IVANHOE- STAGE 1

DESIGN EXCELLENCE REVIEW PANEL WORKING DOCUMENTS

IVANHOE- STAGE 1
INDEPENDENT DESIGN EXCELLENCE REVIEW
FEBRUARY 27 2018/ SUITE 11, LEVEL 12
101 BATHURST STREET< SYDNEY

The following records the minutes of the independent design excellence review panel meeting of 27 February 2018 together with comments, following agenda, a summary list of recommendations to the project team for further review and consideration

01 C1 COMMUNAL OPEN SPACE
1:100@A1

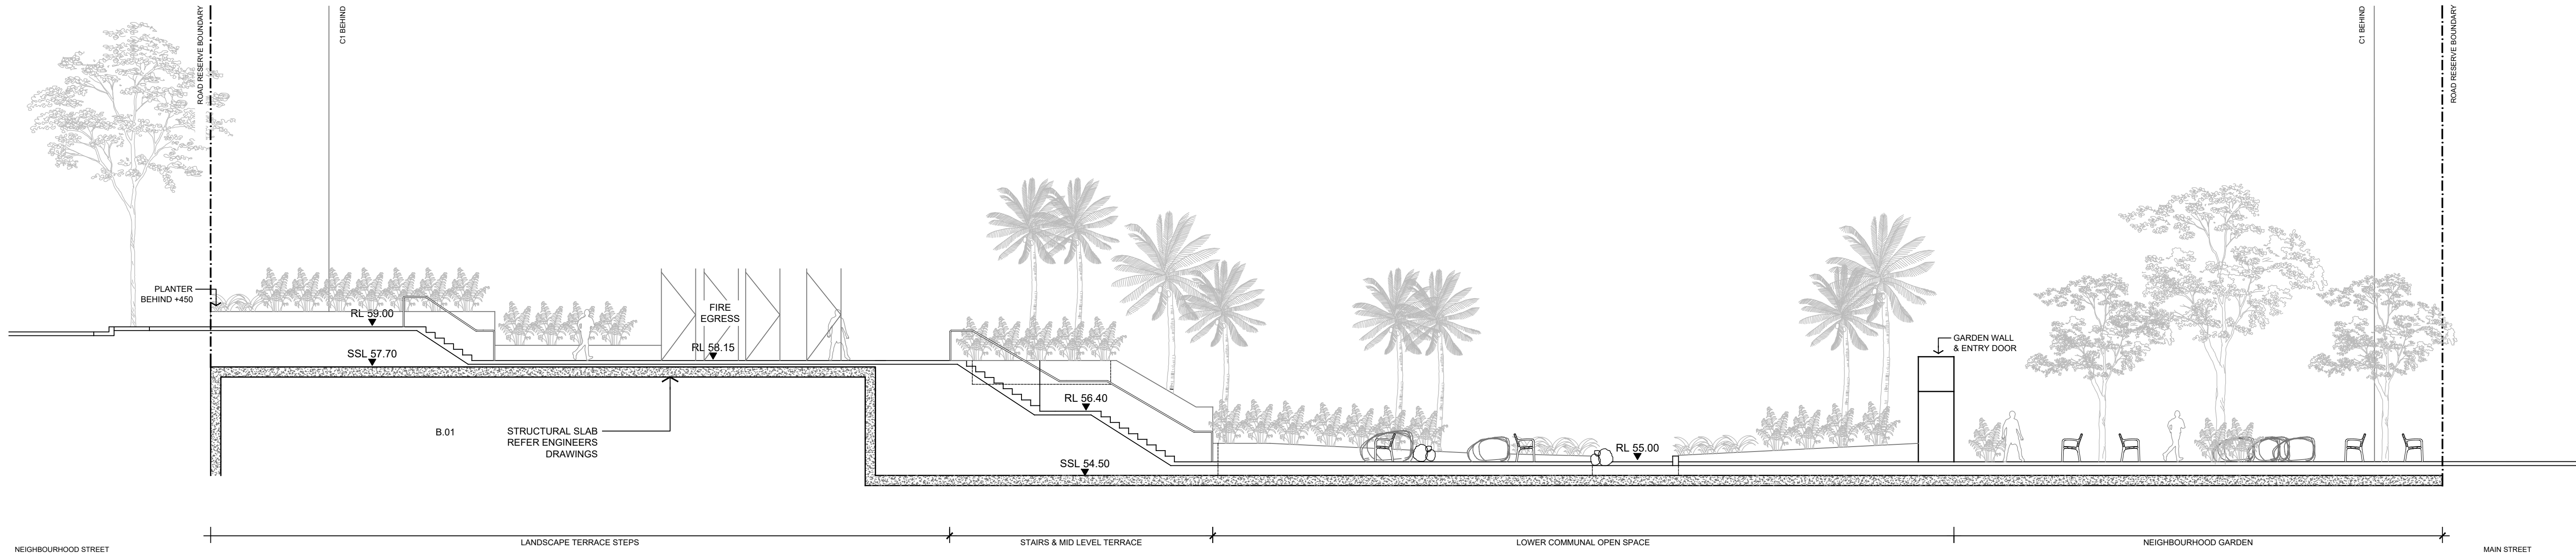
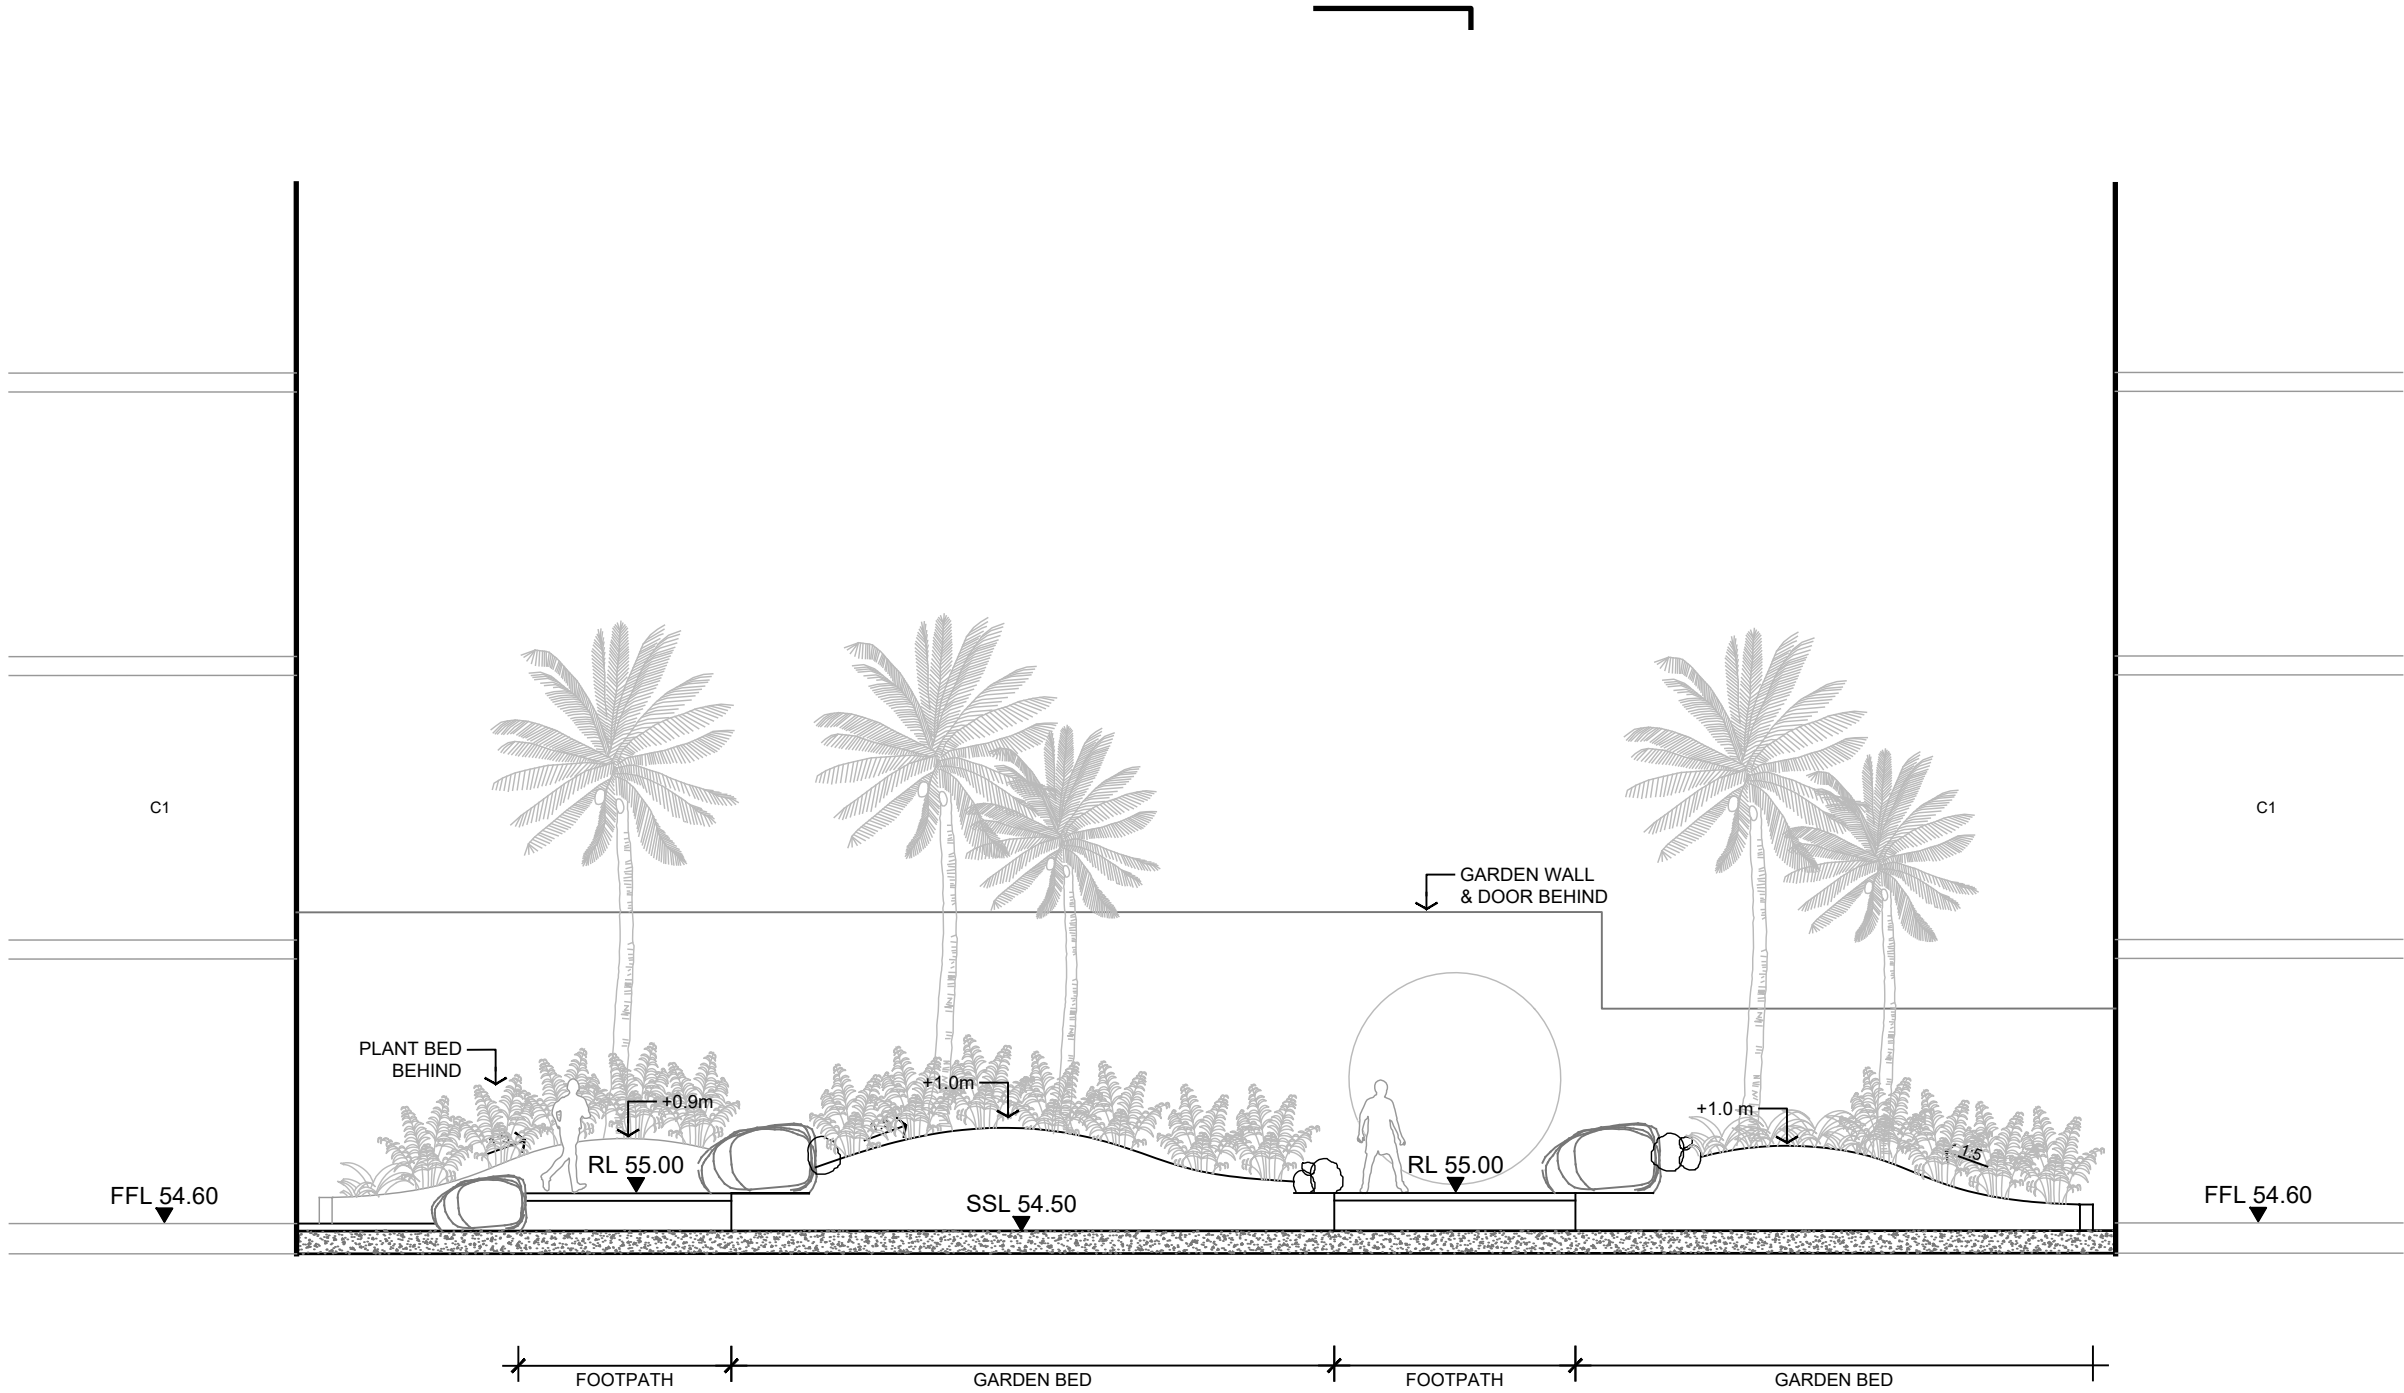
- The panel queried about deep soil zone and the quality of planting in the communal open space. The panel recommended the project team to review the soil depth to allow for trees to mature in the future

- The Panel queried the level changes within the communal open space. The panel suggested more definition between the public and private spaces
- All attendees commended the architect's choice of the earthy pink colour of C1 façade, the proposed materials palate and façade detailing
